WEST SUSSEX COUNTY COUNCIL CONSULTATION

TO:	Arun District Council FAO: Simon Davis
FROM:	WSCC - Highways Authority
DATE:	23 December 2019
LOCATION:	Land east of Shripney Road & south of Haddan House, Shripney Road, Bersted, PO22 9NW
SUBJECT:	BE/109/19/OUT Outline application with some matters reserved for up to 46 No dwellings together with access. This application is a Departure from the Development Plan. More information received.
RECOMMENDATION:	More Information
S106 CONTRIBUTION TOTAL:	provided separately

DATE:	DRAWN BY:	CHECKED:
21/10/19	BL	DT

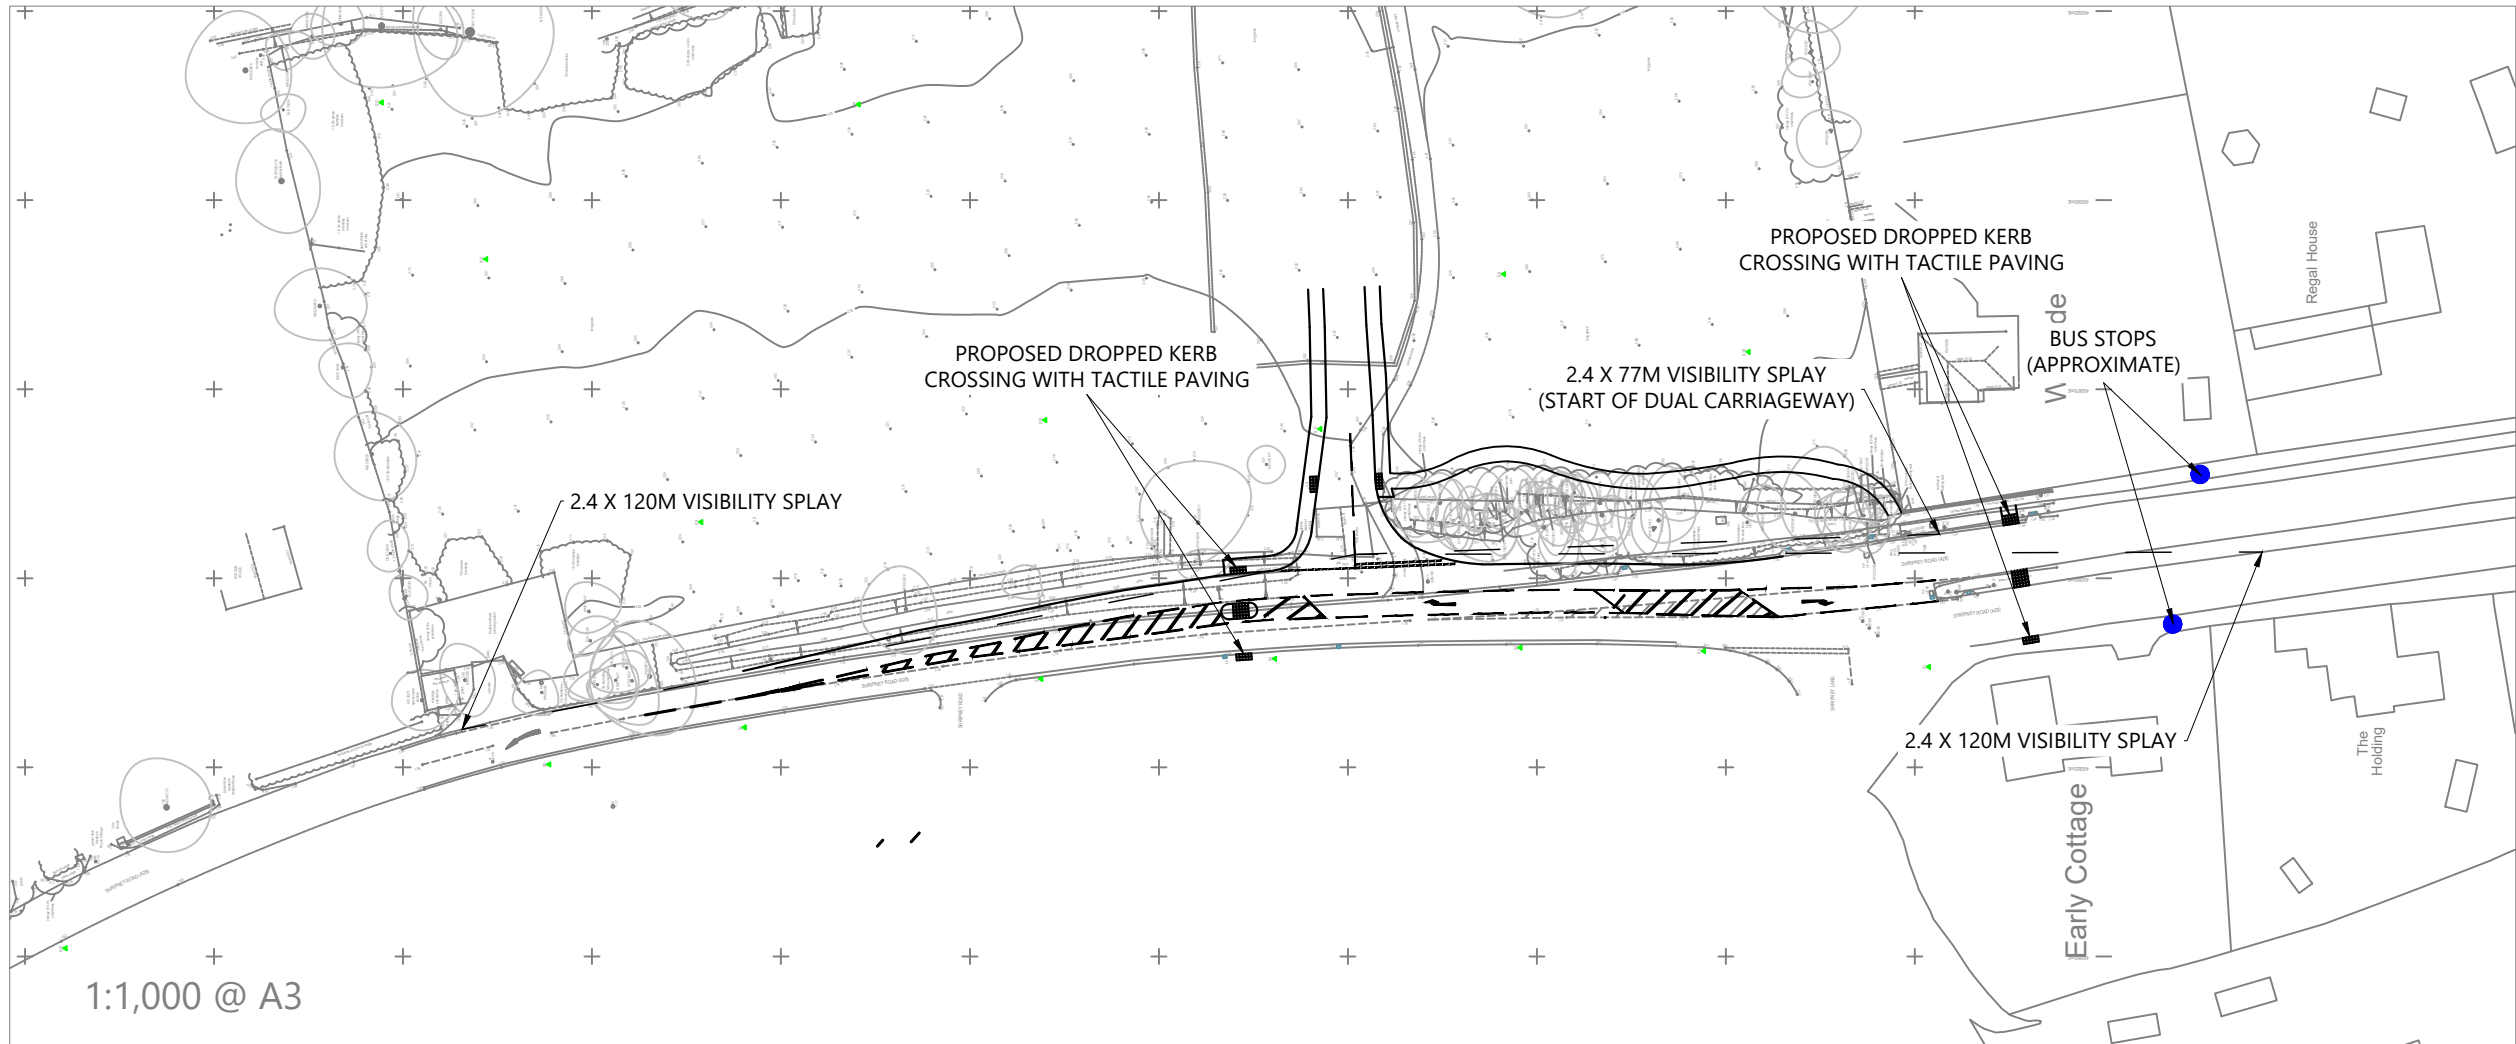
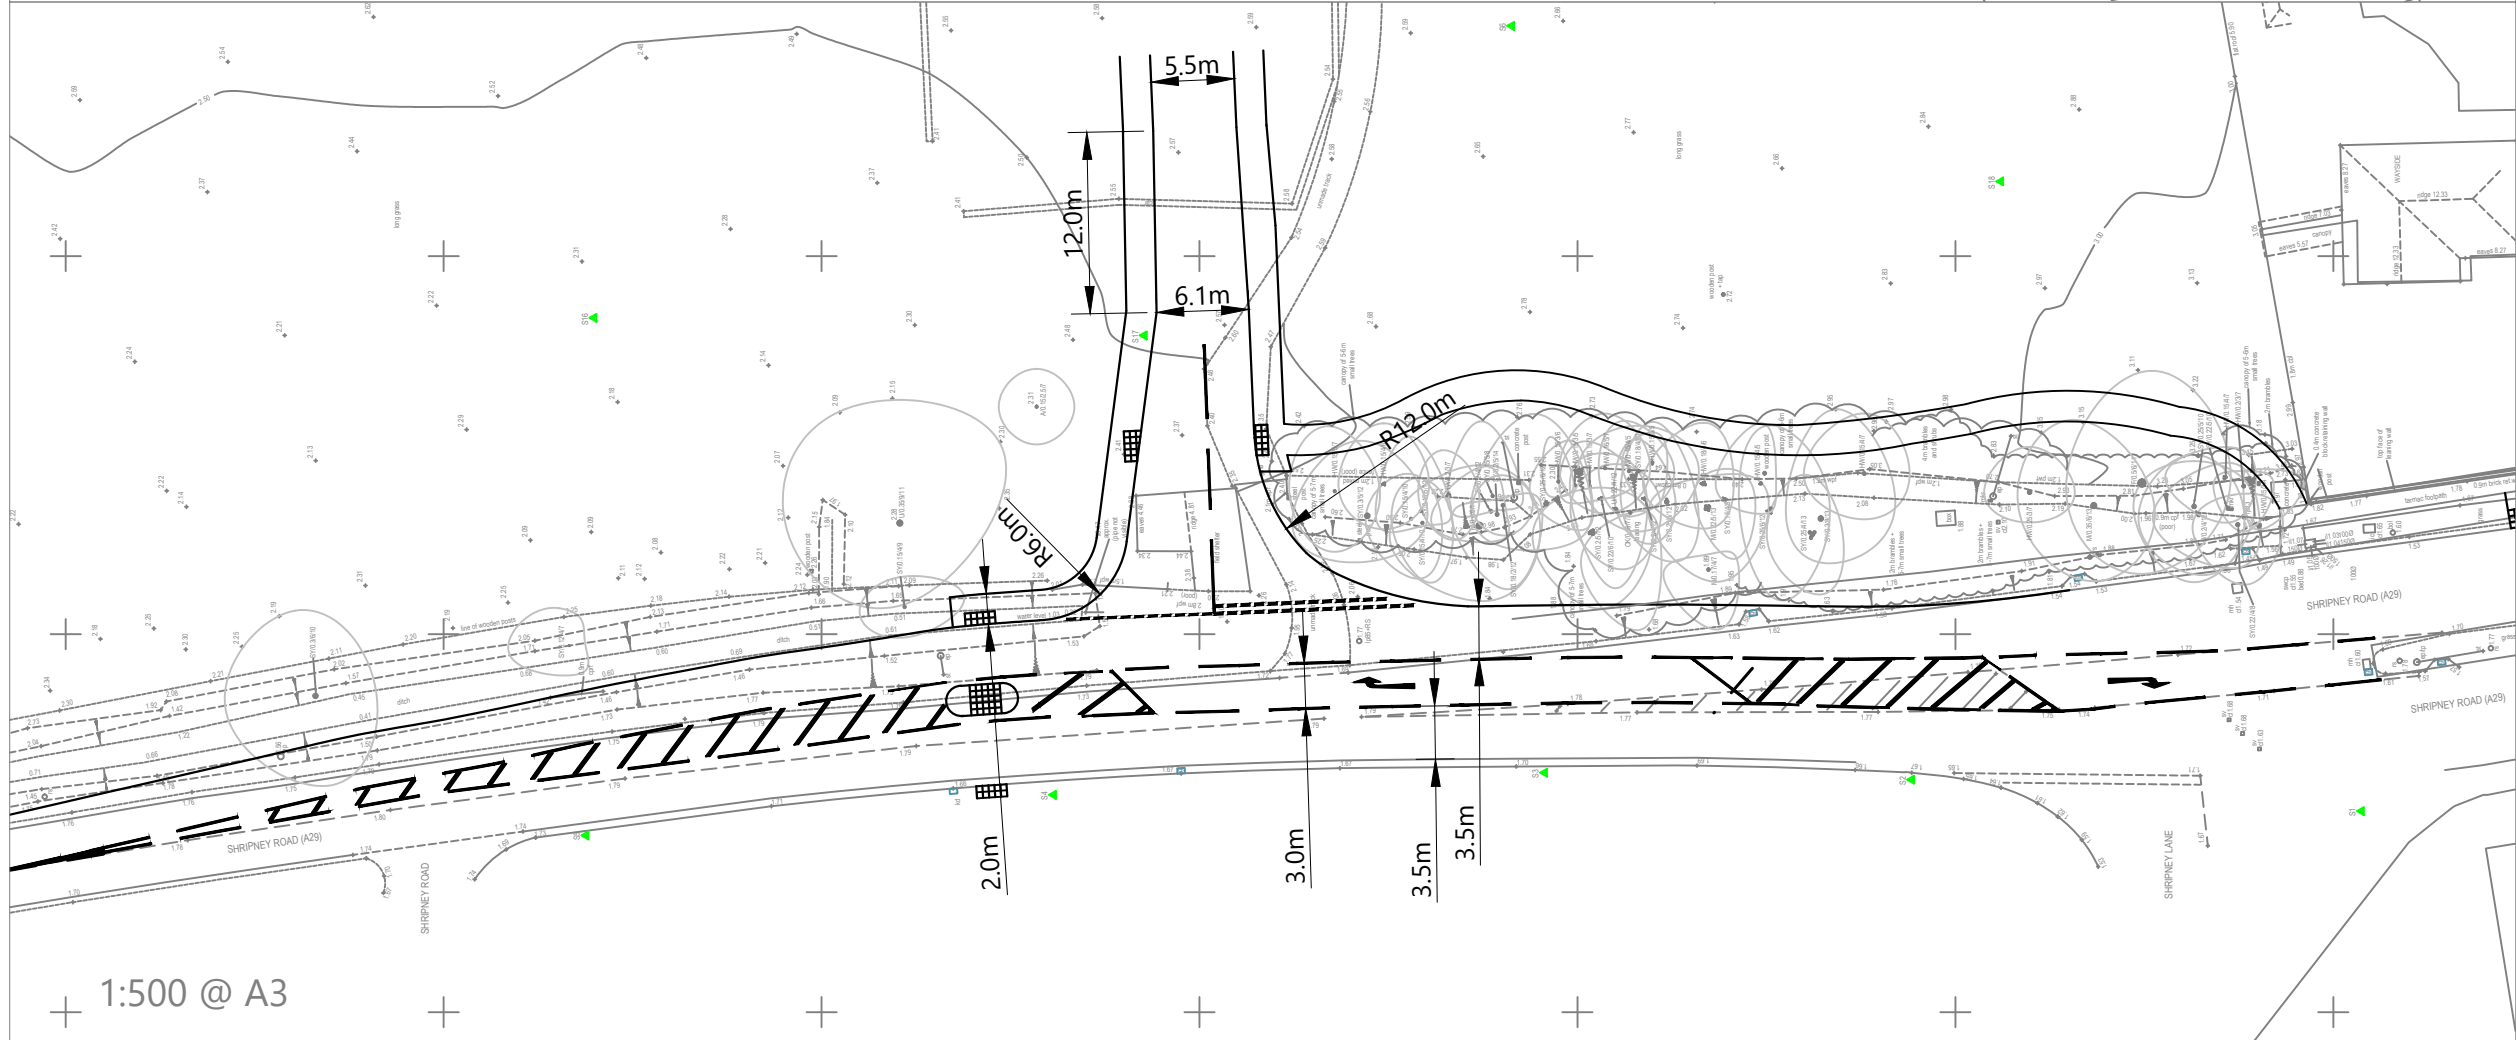
Auditor has raised that larger vehicles encroach opposite carriageway when turning left out of junction or right in to access which could lead to conflict with vehicles waiting at junction. Auditor recommends junction reconfigured to allow larger vehicles to manoeuvre without encroaching on oncoming/waiting traffic. The DR states that access radii will be widened either side of access. The *Revised Proposed Site Access Arrangement* (drawing no. 1845 05 Rev B) shows widening of the bellmouth and increase southern kerb radii to 12m. The northern kerb radii has not been increased and remains at 6m. Whilst amended swept path plans have been provided showing that two refuse collection vehicles can pass in access and not cross carriageway, a Design Audit of the proposed access and right hand turn lane has not been provided. This should be

provided and include justification against standards for kerb radii on both sides and all other proposed highway modification/ junction works including right hand turn lane.

The Transport Consultant states that an additional dropped kerb pedestrian crossing is proposed just after start of dual carriageway. The LHA raise concern with location of this across dual carriageway as pedestrians would effectively be required to cross two lane width at the point where vehicles may speed up to join dual carriageway. The crossing could be located just north of junction with Shripney Lane, within existing hatching. Relocation of proposed new crossing should also be reviewed by the safety auditor. Linking footway could also be provided along eastern carriageway edge to link with

existing footway and tie in to new pedestrian crossing location.

- Design Audit of all access works including new right hand turn lane
- DR provided in table format including readdressing point 2.7.
- Location of speed counter
- Relocate new proposed pedestrian crossing so that this does not cross dual carriageway and safety auditor to review this also
